ASSESSMENT REPORT

Arts and Social Sciences Building, Sydney University SSD 7081 MOD 1

This report is an assessment of an application seeking to modify the State significant development (SSD 7081) consent for the construction of a new Faculty of Arts and Social Sciences (FASS) building at The University of Sydney, Camperdown, Sydney.

drawing no.	DA1070	issue	H
-------------	--------	-------	---

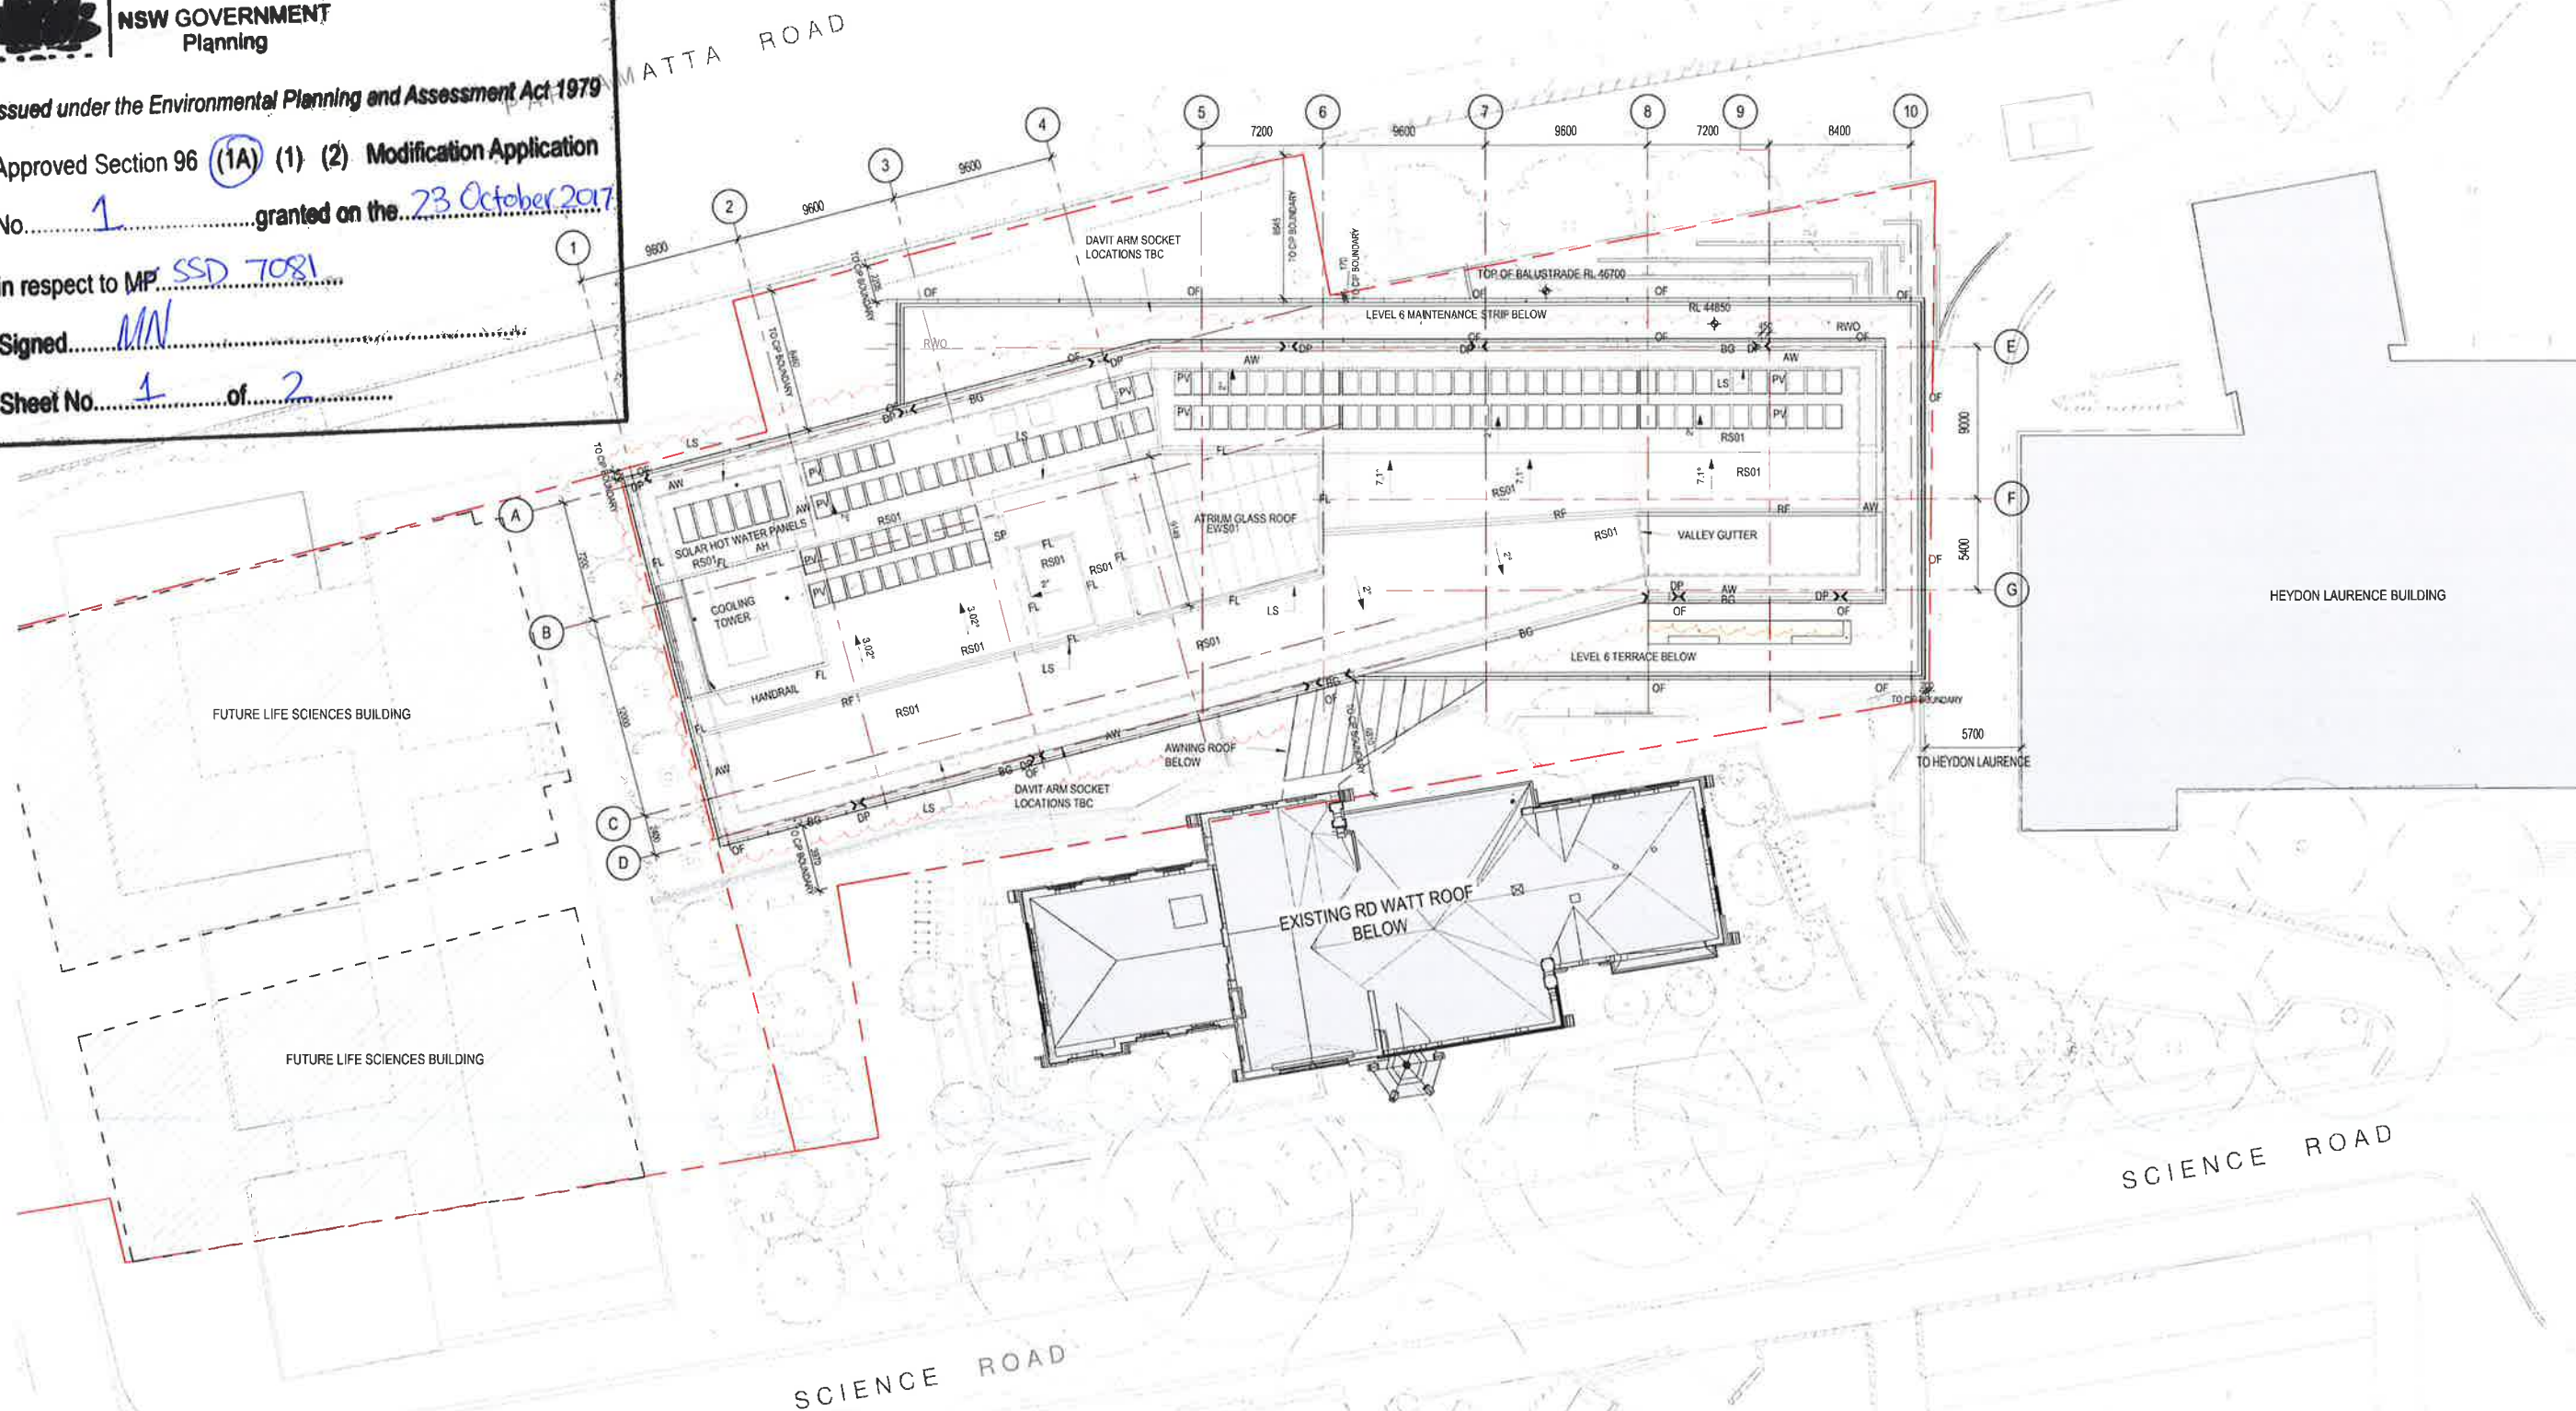
The proposed modification seeks approval to change the colour of the roof sheeting on the FASS Building from Colorbond 'Gully' to Colorbond 'Surfmist' to meet the University's Sustainability Framework requirements.

- the flat roof design of the FASS building means the roof sheeting would not be readily visible from the surrounding public domain and, as such, the proposal would not alter the approved design and appearance of the FASS building, or result in any additional visual or heritage impacts;
- the proposed roof colour would improve the SRI and overall environmental performance of the building; and
- no physical change to the roof is proposed.

The Department also notes the proposed roof colour is not expected to result in any reflectivity or glare nuisance and an existing condition of consent (Condition B9) appropriately limits the maximum reflectivity of building materials to be used on the site.

The Department's assessment therefore concludes the proposed roof colour is acceptable. Consequently, the proposal is in the public interest and it is recommended that the modification be approved.
